ARUN DISTRICT COUNCIL

6 VICARAGE LANE
BOGNOR REGIS
PO22 7DY

RE. FP 104 18 HH

sheet 4 of 6

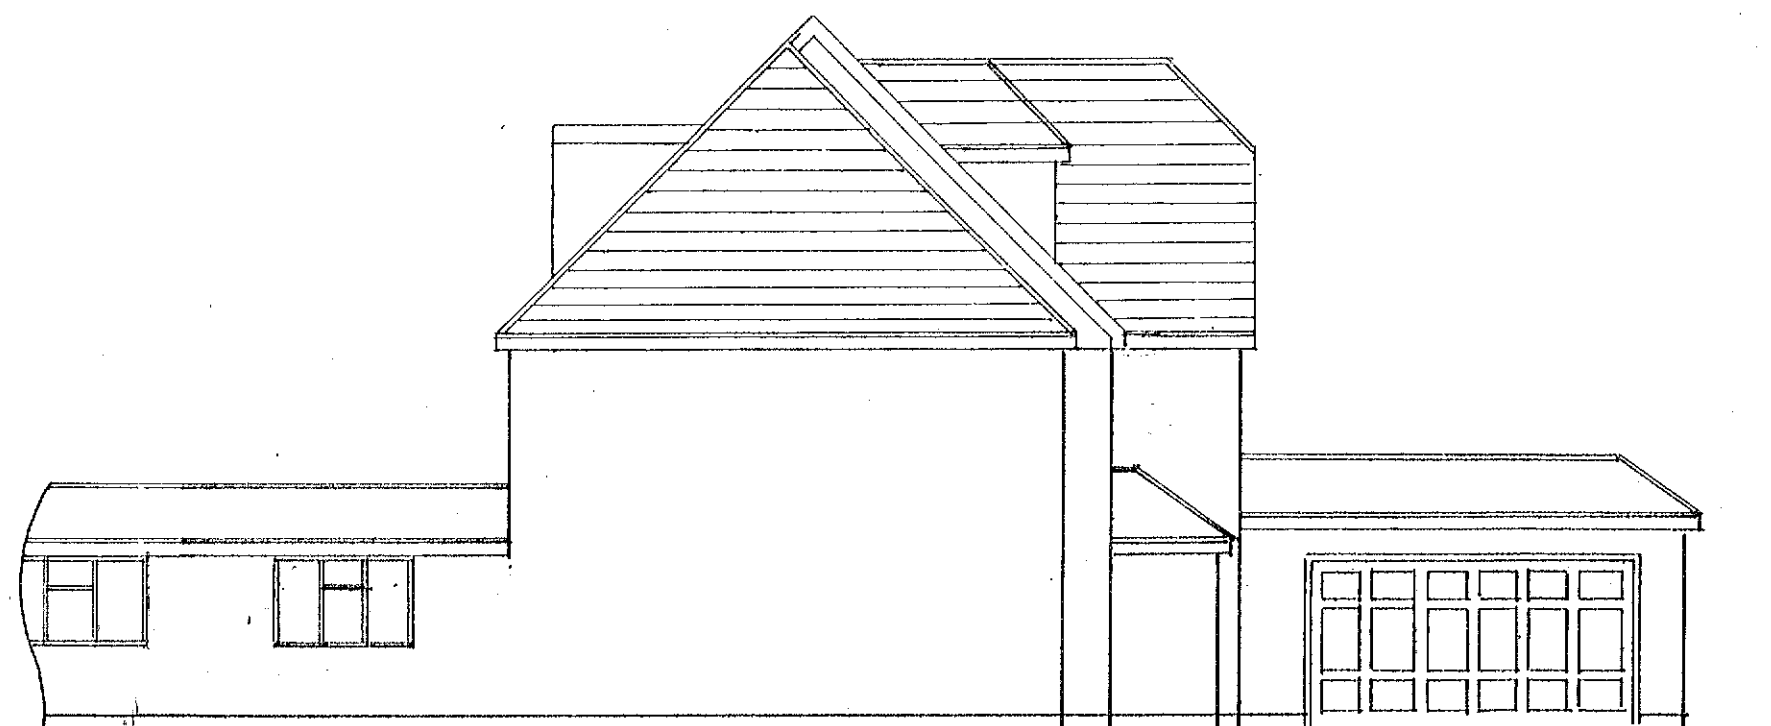
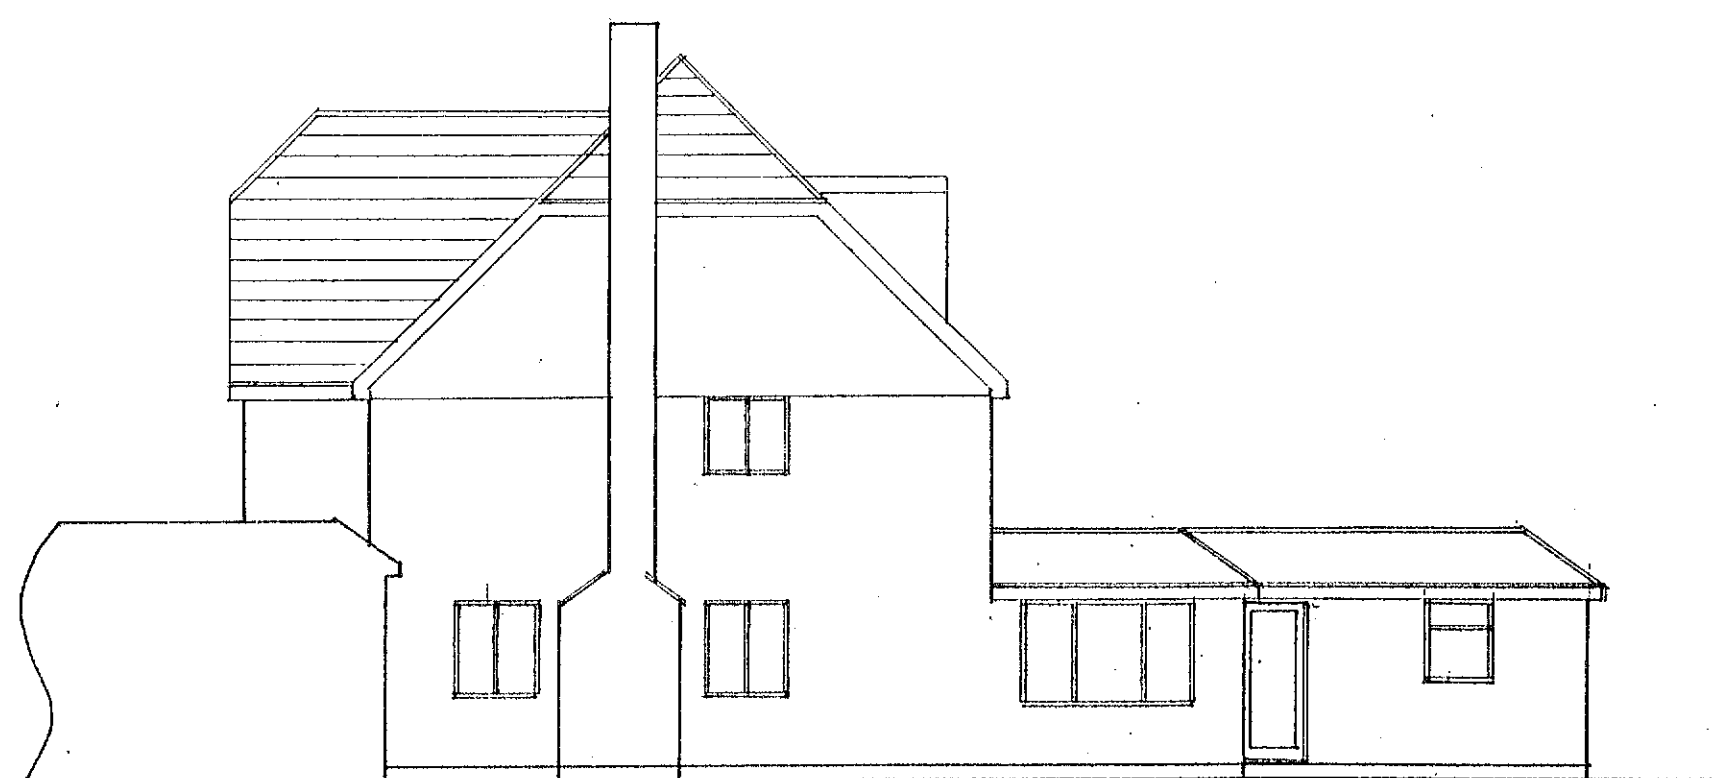
As the property (which has been
extended many times over the years)
is situated on elevated land it
tends to dominate the central section
of Vicarage Lane. I feel that to
build dormers in the roof would
merely add to the incongruity of
the building with its neighbouring
properties. My other concern is of
privacy, with dormers overlooking my
own house on the opposite side of
the road. Unfortunately there is no
natural screening (the owners having
removed trees some years ago) which
might have alleviated the effect.
